1. New Primary School in Mulgoa Rise – 1-23 Forestwood Drive – Glenmore Park

ptc. has been engaged by Richard Crookes Construction on behalf of School Infrastructure NSW (SINSW) to address comments received following the submission of the State Significant Development Application (SSDA) for the proposed development of a new primary school located at 1-23 Forestwood Drive in Glenmore Park. The Transport and Traffic Assessment dated 20 August 2021 and submitted as part of the SSDA was prepared by **ptc.**

This letter has been prepared in response to the following documents:

Figure 7 – Bus Zones at Pedestrian Holding Area

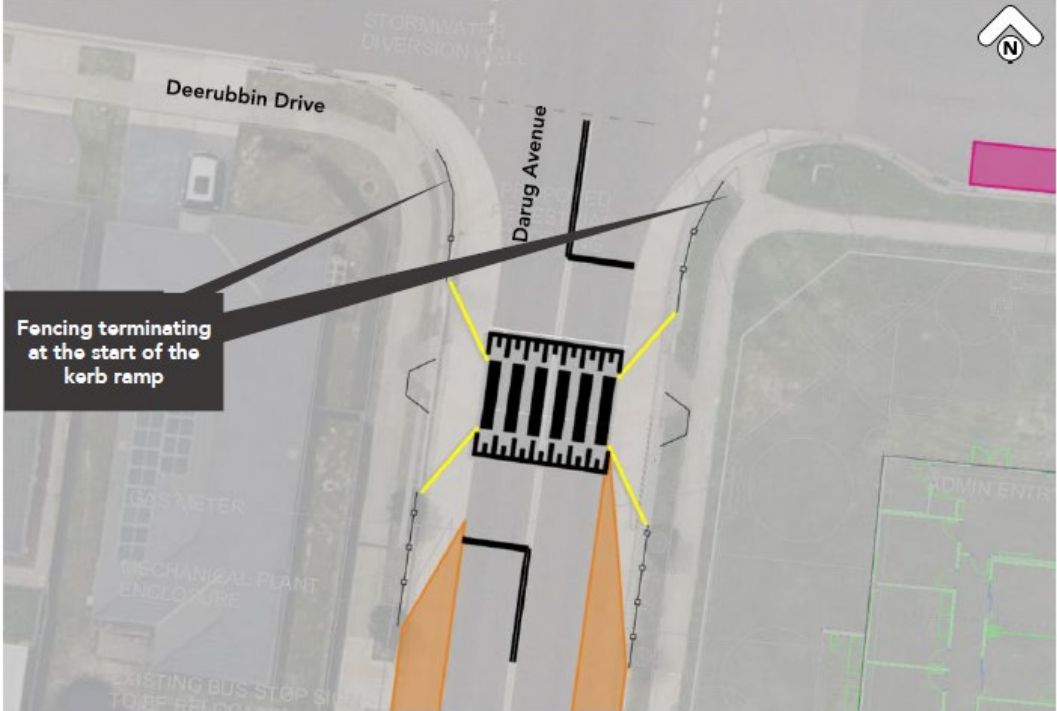
iii) The existing bus stop boarding points should be related to align with the adjust 'Bus Zone' boarding point location and replaced with Council and DDA complying bus stop boarding points and bus shelters to Council satisfaction. Consultation shall be undertaken with Busways, TfNSW Bus Section and effected nearby residents and their acceptance or other comments provided with the application.

It is not proposed to relocate the boarding point on the western side of Darug Avenue, as there is no requirement to do so. Refer to Section 2.2 for the relation between the zebra crossing and the bus stops.

The eastern boarding point has already been addressed in the SSDA TTA, where it was relocated south by 5m due to the zebra crossing design.

The location of bus stops and boarding points at Darug Avenue are presented in Figure 7.

Figure 10 – Proposed Zebra Crossing Design

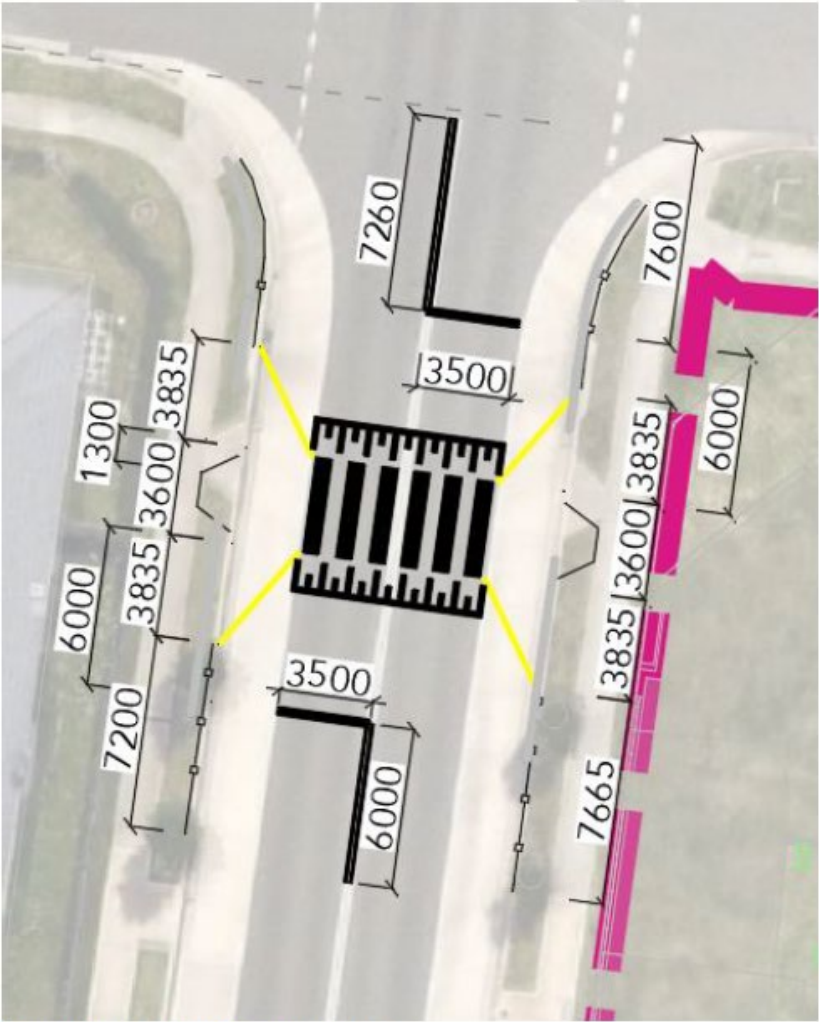
The proposed at grade pedestrian crossings must be raised and conform to Council's general design for raised combined pedestrian / children's crossings. The crossings must be a combined raised pedestrian crossing and children's crossing with raised shoulder medians, no fencing on the shoulders as shown proposed, with red and white poles, approach TF holding lines, children crossing flags and No Stopping zones complying with TfNSW guidelines.

As per information provided to the authorities and discussions held as part of the TWG meetings, there is a flooding issue within the surrounding roads which prevents implementing any raised infrastructure within the carriageways (refer to documents prepared by Woolacotts: the Overland Flow Flooding Summary dated 27 July 2021 and the Flood Impact Assessment dated 22 October 2021).

A revised at grade zebra crossing design is shown in the below figure and in **Attachment 1**, with the yellow lines representing fencing (or any other structure i.e. bollards that would be deemed acceptable) to imitate the kerb build outs. This is so that the impact on the water flow within the carriageway is minimised.

Figure 14 – Vehicle Holding Area at Darug Avenue

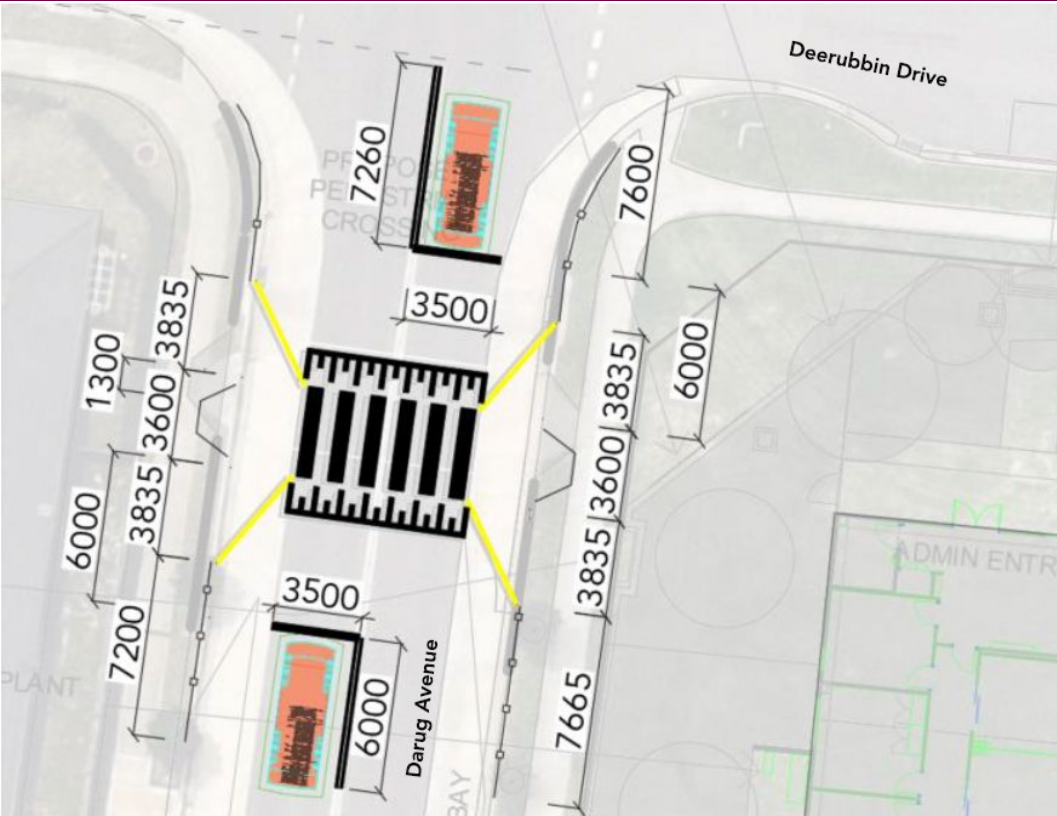
The proposed crossing in Darug Avenue and in Forestwood Drive should be relocated to provide at least 13m of queuing clearance (to allow for two cars or one HRV or bus) from the Deerubbin Drive and Forestwood Drive through traffic to the TF holding line which should be located 6m from the edge of marked pedestrian crossing.

The zebra crossings have been relocated following the detailed design and they are now located as follows (refer to Figure 14 and Figure 15):

- 7.6 m long vehicle holding area is provided on Darug Avenue allowing for 1 car to wait, and
- 14.7m long vehicle holding area is provided on Forestwood Drive allowing for 2 cars or 1 truck to wait.
- Additional 6m distance from the zebra crossing to the stop line is provided at both crossings, as per the guidelines for children's crossing.

Lengthening the distance of the Darug Avenue crossing to a distance of 13m from the intersections is not seen as required and is not recommended for the following reasons:

Figure 12 – Proposed Pedestrian Fencing at Deerubbin Drive

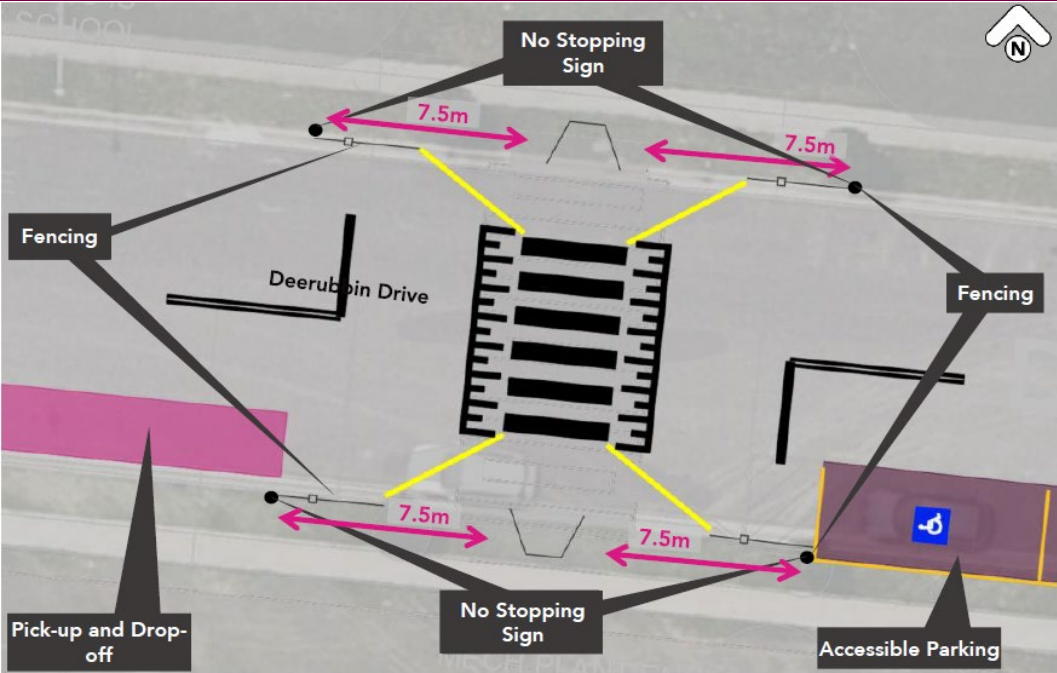
There should also be pedestrian fencing provided on the verge at the back of the kerb, at the crossing 'No Stopping' zones on each side to direct pedestrian to the crossing.

Fencing is proposed on the verge at the back of the kerb from the zebra crossings to the pram ramps at intersections, from zebra crossings to 'No Stopping' or a distance of 7.5m at the midblock, at the start or end of bus bays and up to the driveways of the adjacent properties. The proposed fencing at Darug Avenue, Deerubbin Drive and Forestwood Drive are presented in Figure 11, Figure 12 and Figure 13 respectively.
